Your Ref: FG/33/18/PL
Date: 19th March 2018

**Re: Land at the former McIntyre Nursery, Littlehampton Road, West Sussex BN12 6PG
Demolition of polytunnels, use of land for Class B8 container self-storage and the
siting of 42 single-stacked storage containers, an office/toilet portacabin, new fencing,
gates, CCTV, lighting and alterations to the entrance.**

TITLE PROPOSED SITE & BLOCK PLAN	DWG NO 5285-2	REV C
--	-------------------------	-----------------

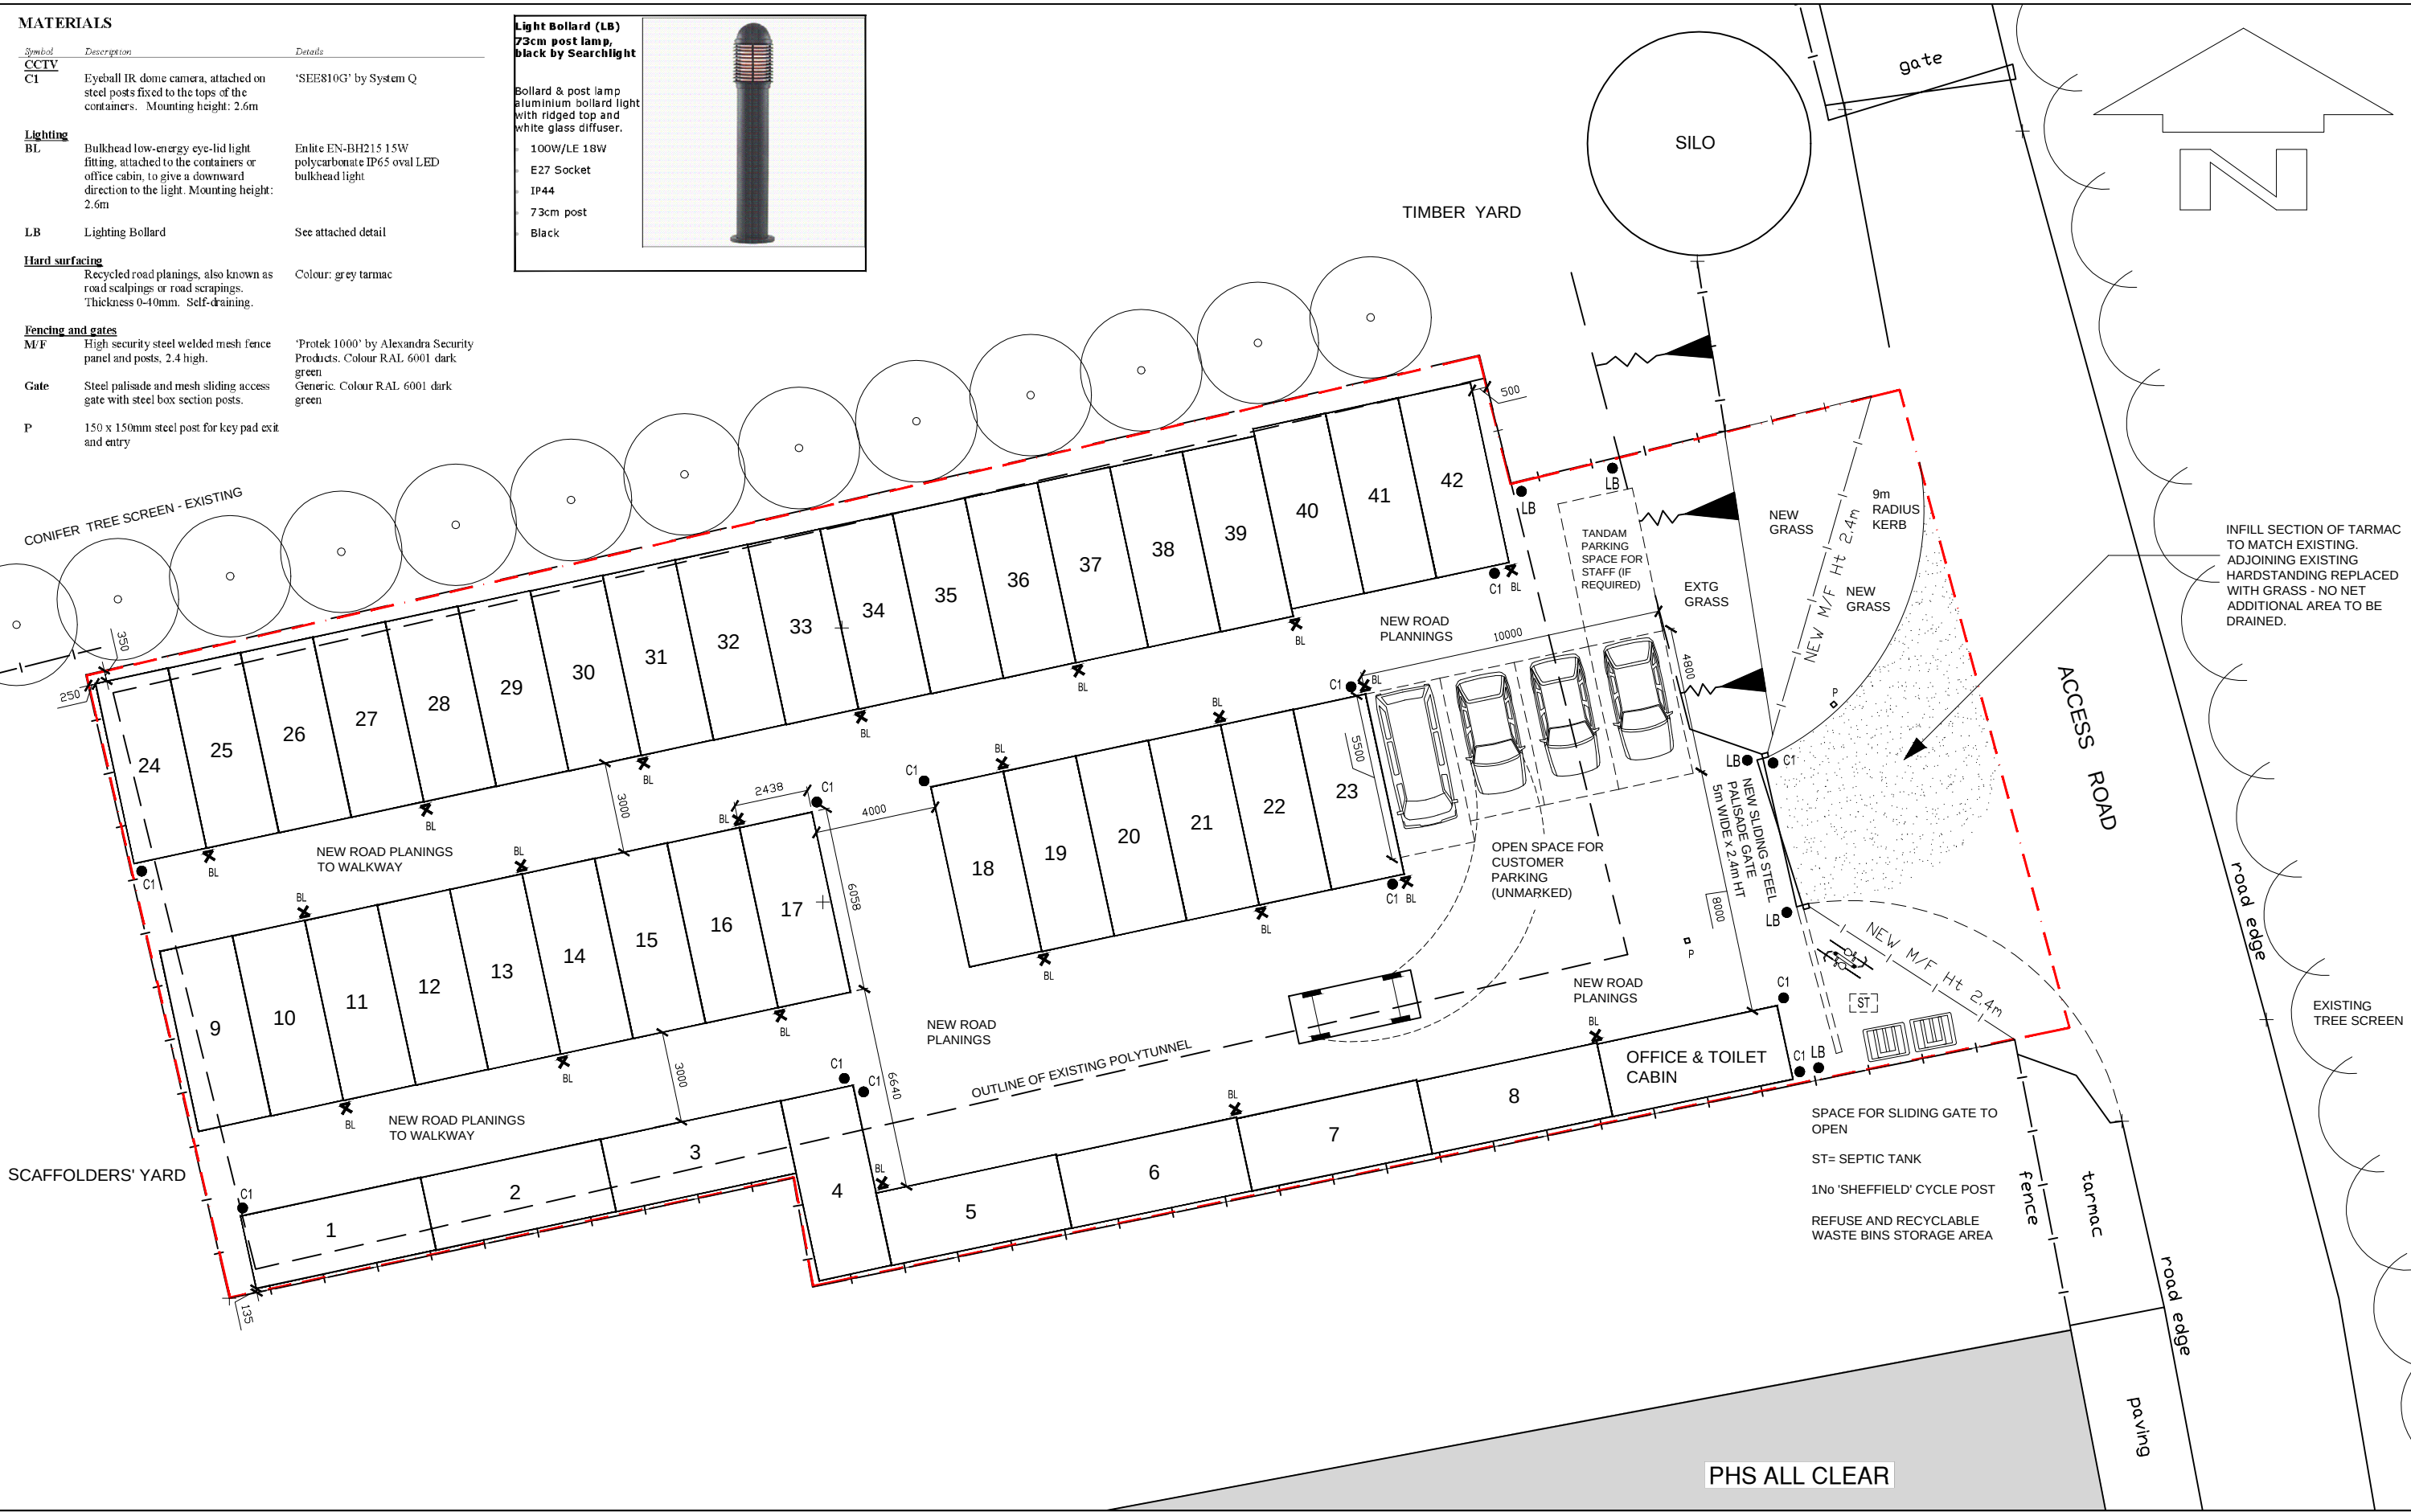
I note from the online Planning Register that the County Highway Authority have responded on the 14th March to the statutory consultation with a request for further information. Specifically, clarification of how the containers would be delivered and removed from the development site.

It is proposed to reconfigure the site entrance in order to improve access for a 7.5T flat-bed. The proposed site plan shows a 9m radius hammerhead entrance. The container delivery lorry would perform a reverse side turn into the site from the main access road and eventually exit the site in forward motion. The 9m radius turning circle and 6.11m width of the access road conform with, or exceed, standard highway geometry, rendering a swept path analysis superfluous. The new access point would also offer improved sight lines.

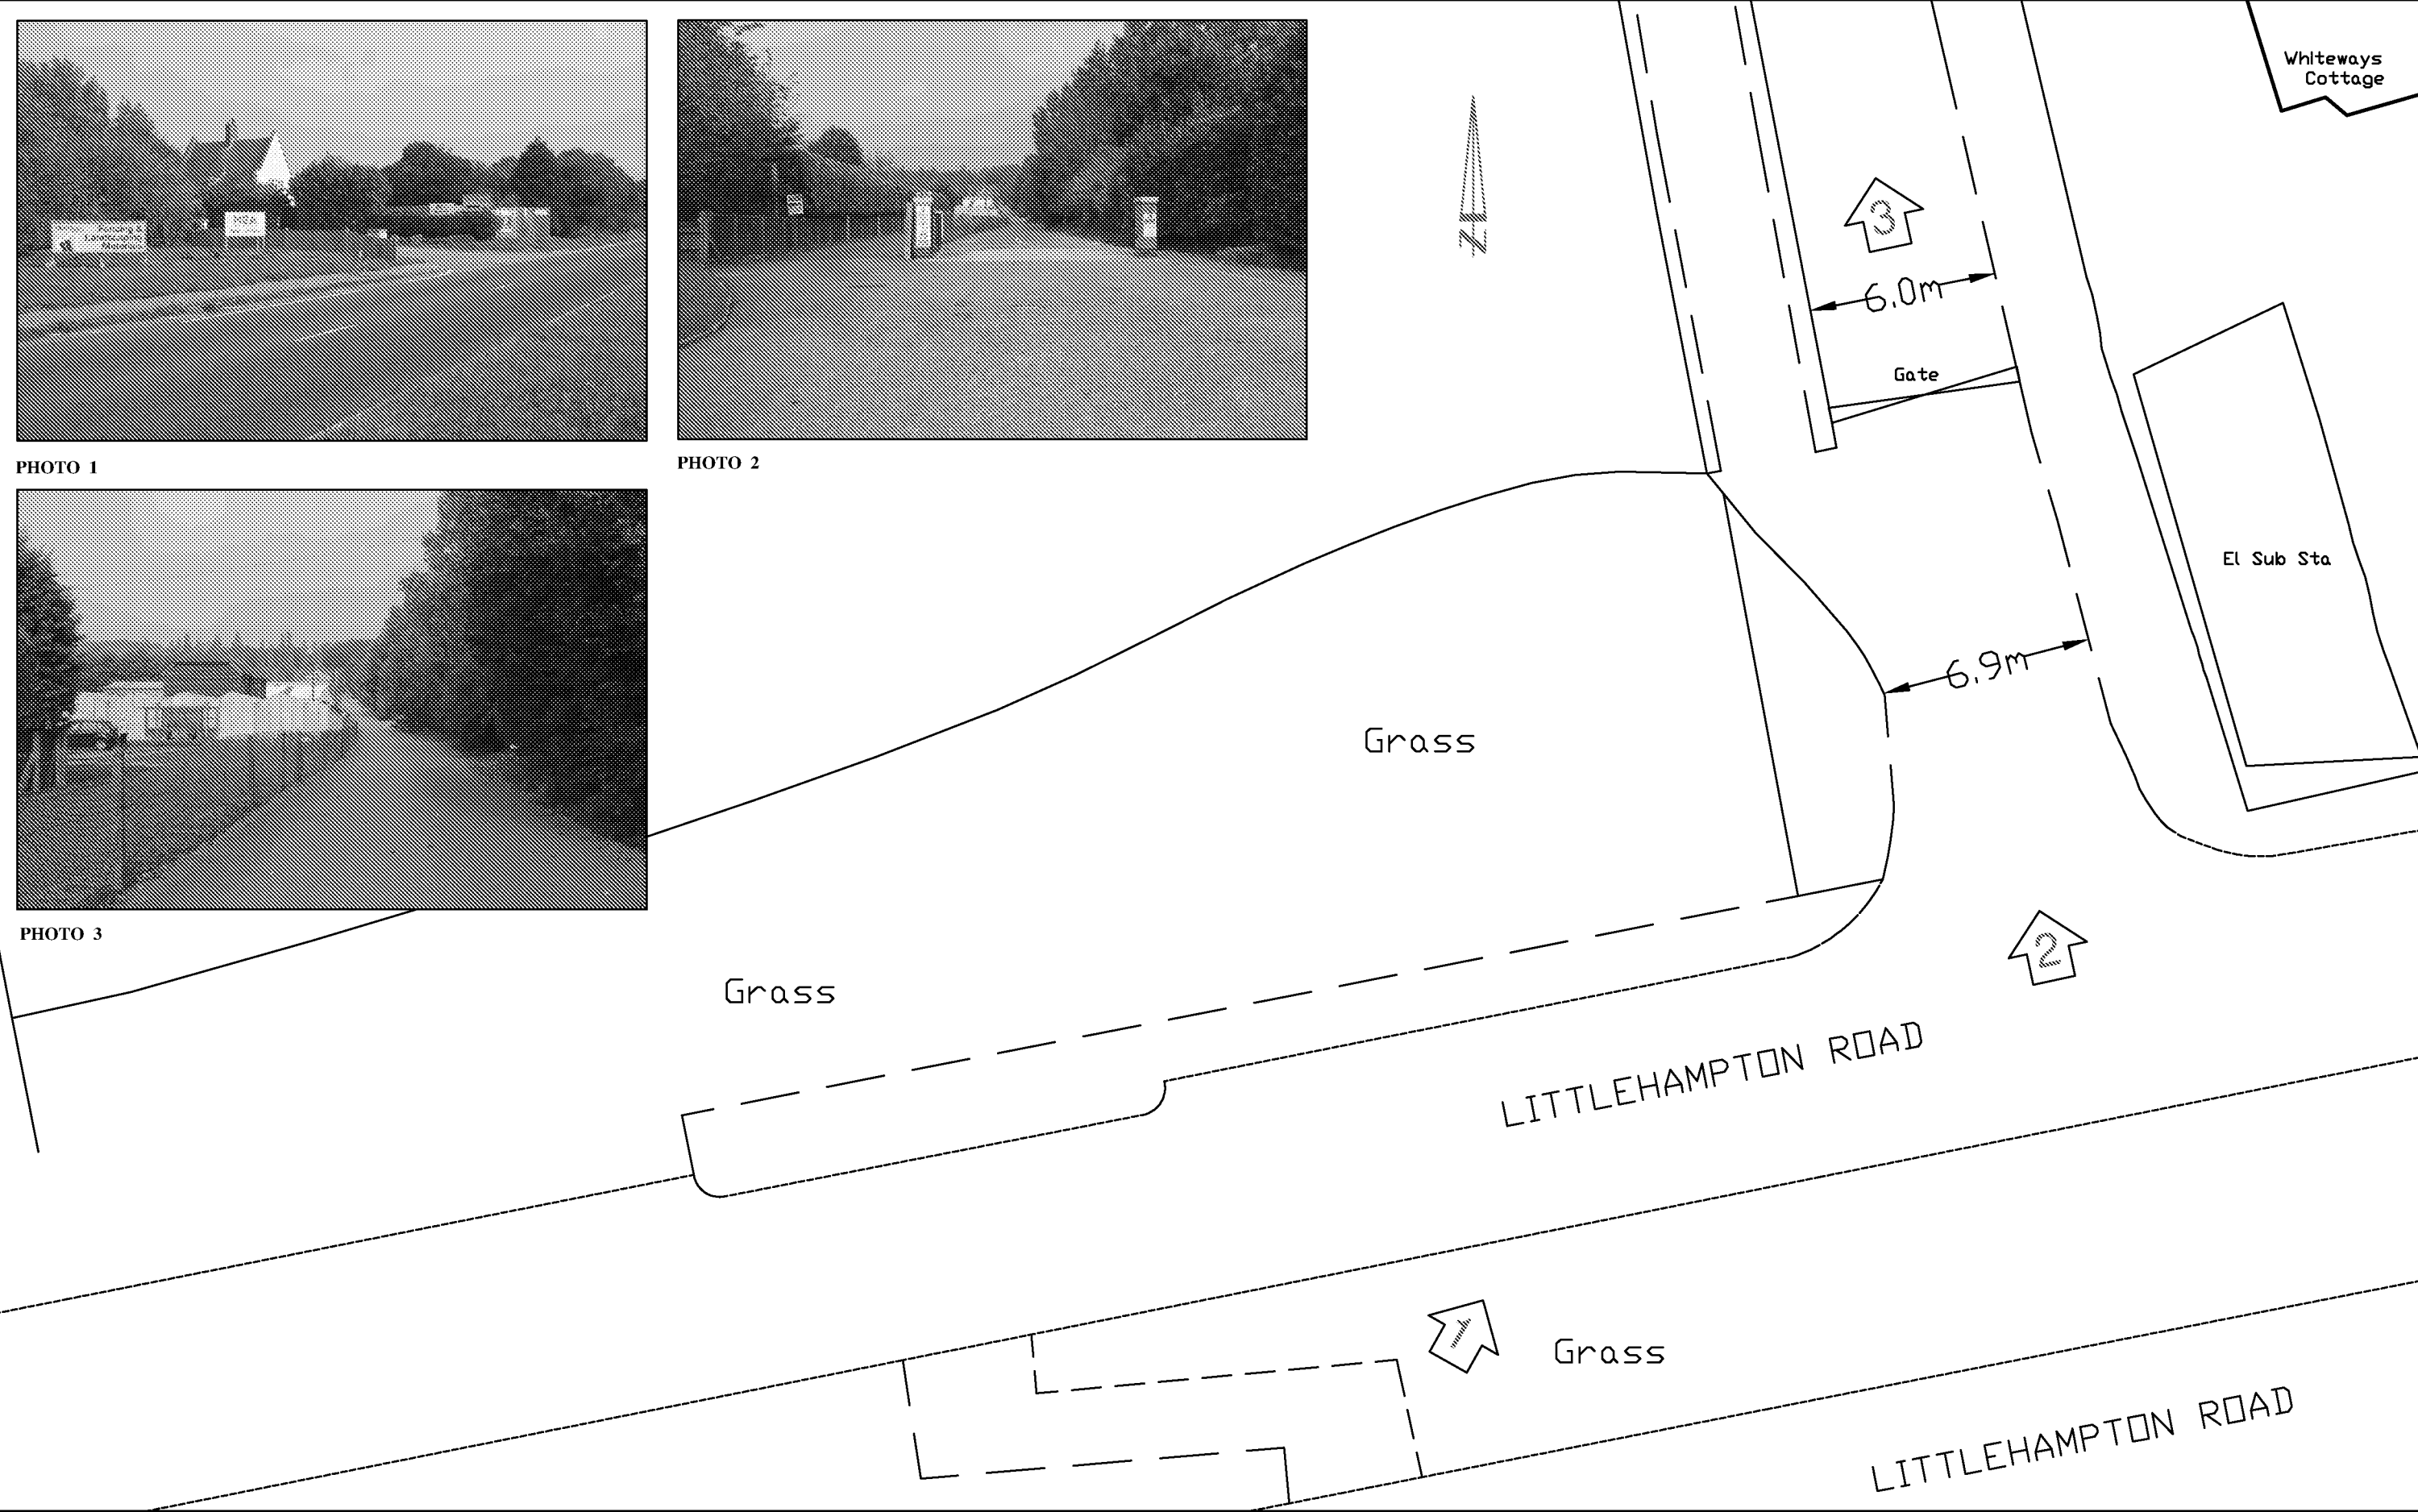
The existing road junction with the eastern carriageway of the A259 is outside the application site. However, a site visit (or 'walkthrough' on Google Maps) should demonstrate that the junction has excellent visibility and good geometry. To illustrate the point, I attach a Highway Plan with photographs. The Planning Inspector for the recent appeal considered the visibility at the junction was "good" (C12/2184306, para. 55). He found it already carried traffic from "heavy vehicles" (para. 16) and there was no objection to development from the CHA.
